**Consultation Response from Ellen Milner,
Yorkshire Wildlife Trust**

2021/93689 Land to the south of, Ravensthorpe Road / Lees Hall Road, Dewsbury

We have reviewed the Eco Impact Assessment (Buro Hapold 12.10.21) and the Bat Survey Report (Penny Anderson, Oct 21) and have the following comments/queries:

STATIC MONITORING DETECTIONS (1)	
SPECIES	OCCURENCE
Common pipistrelle	Frequently
Noctule	Rarely
Myotis species	Rarely

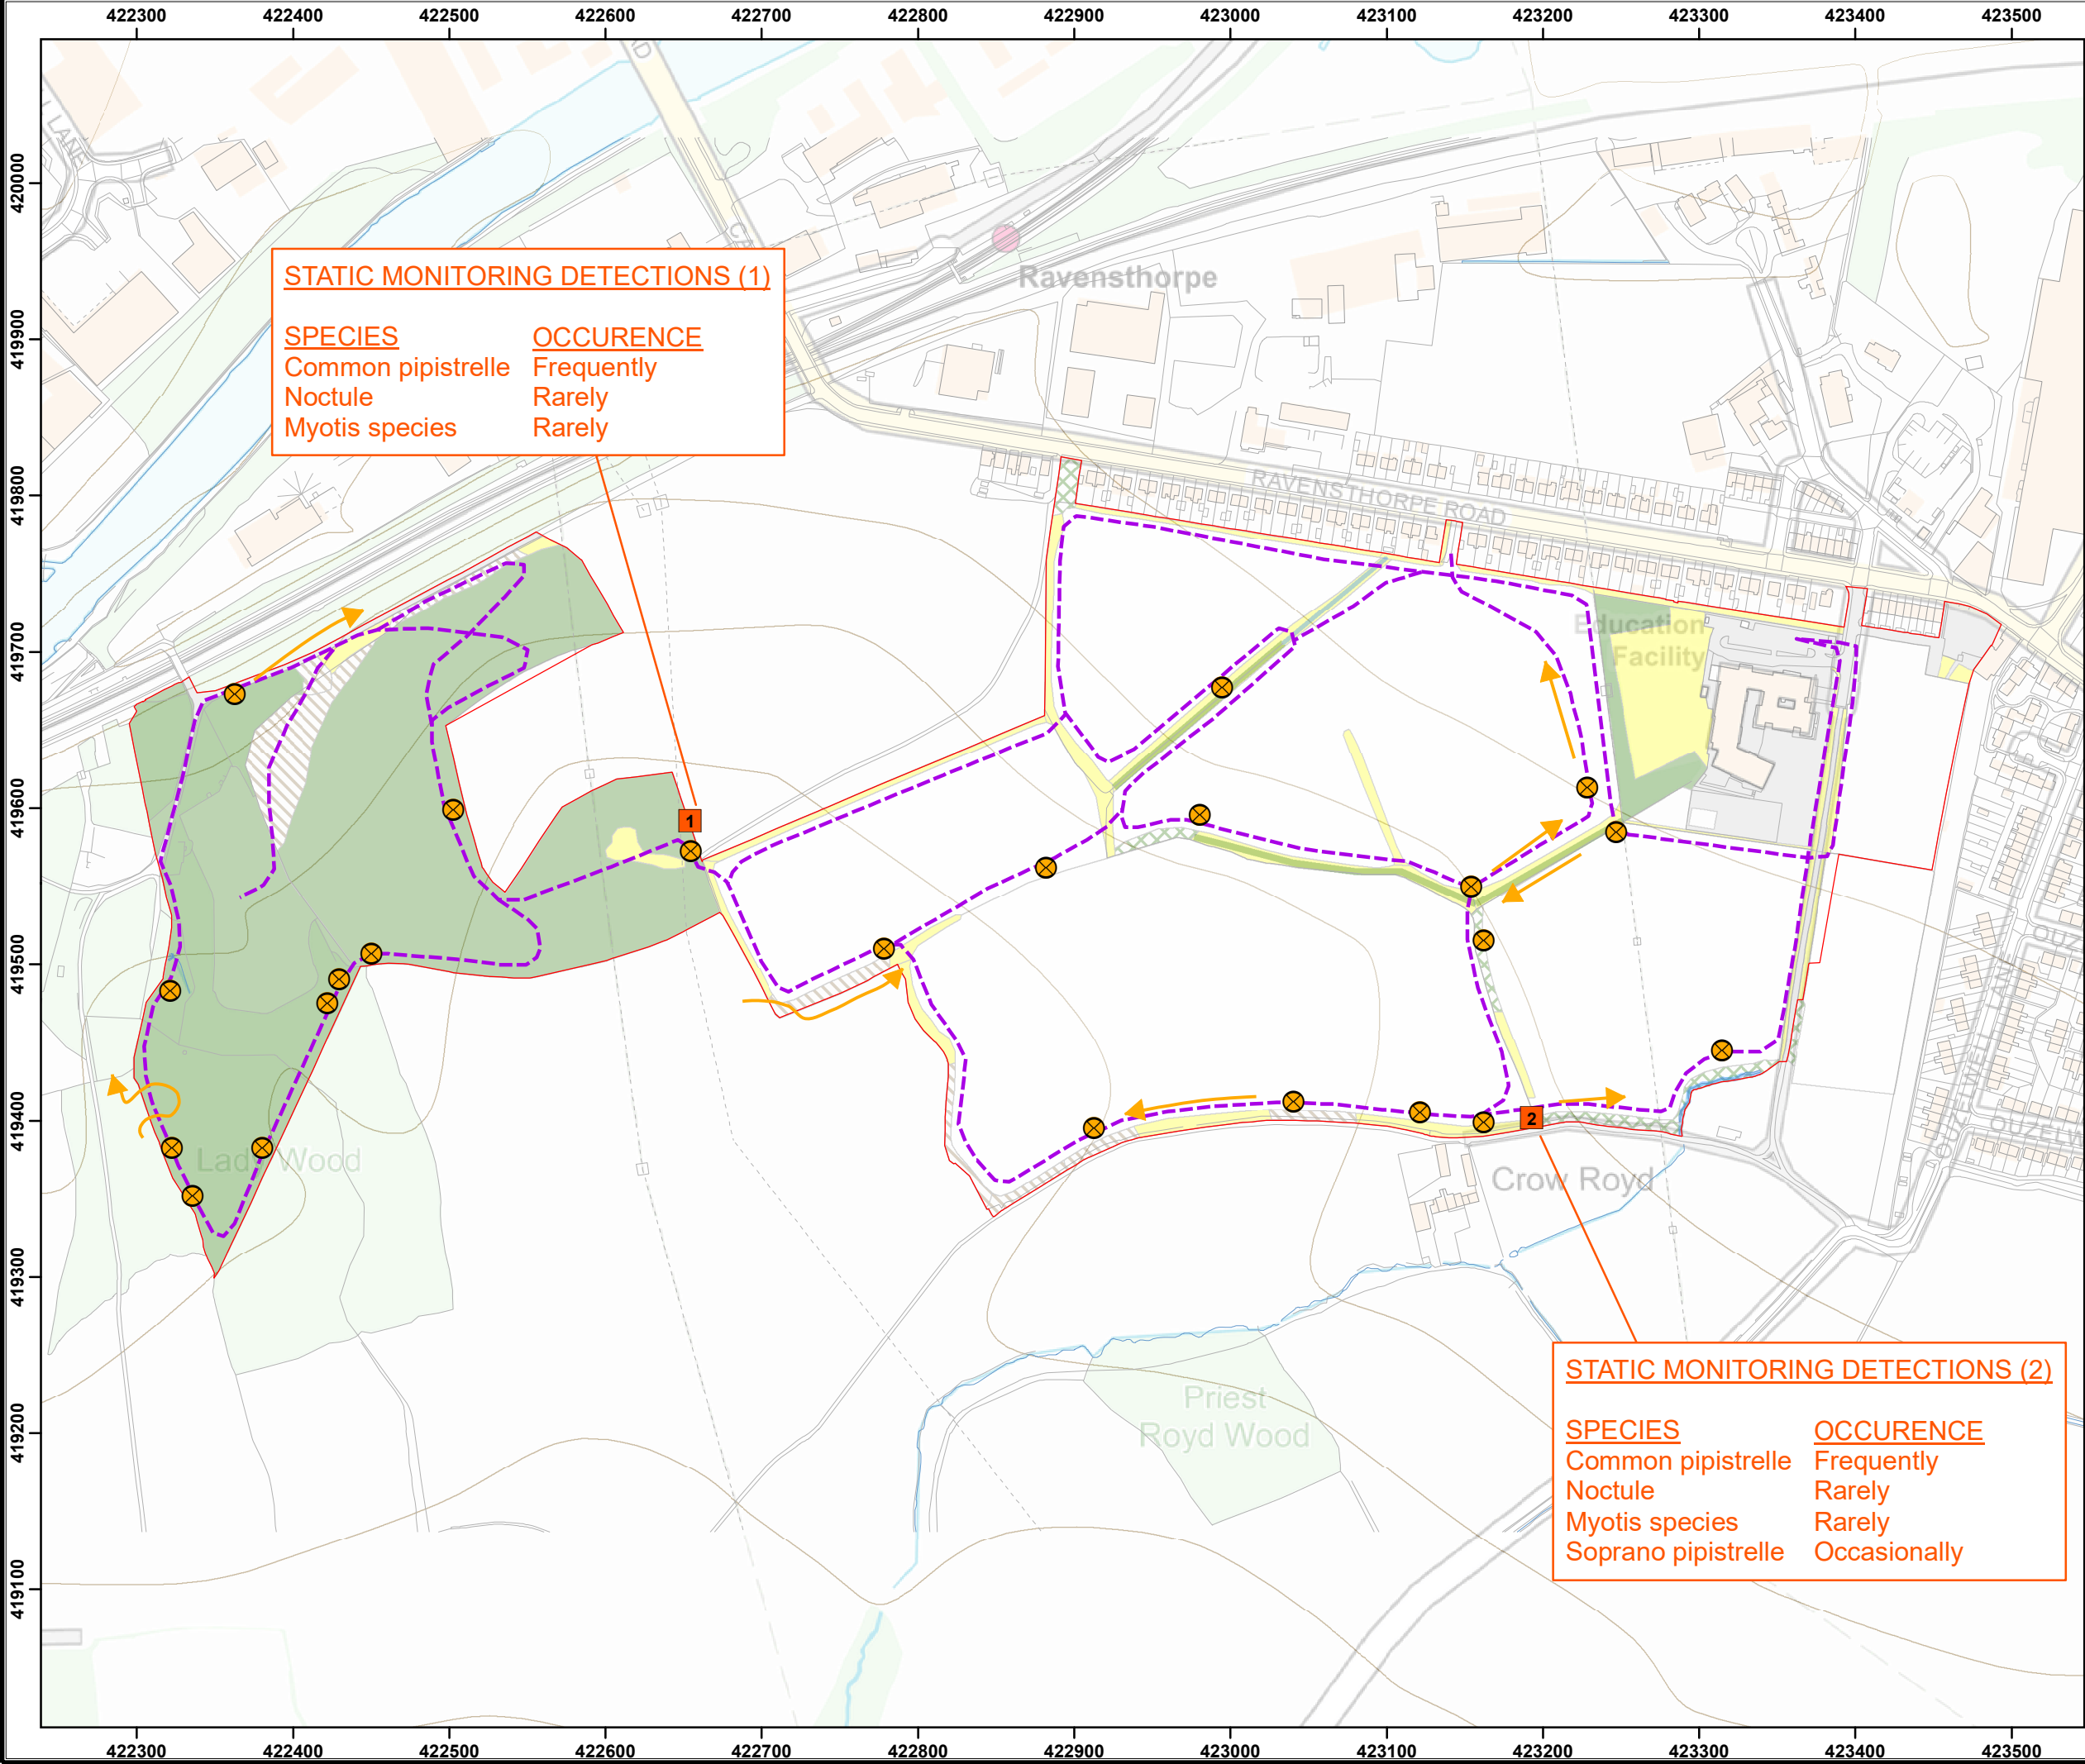
- Some technical issues were encountered which resulted in the loss of data from one of the SM2 static recorders at Location 1 in the second round of monitoring, and at Location 2 in the third round of monitoring – will these surveys therefore be repeated in order to ensure a full dataset?
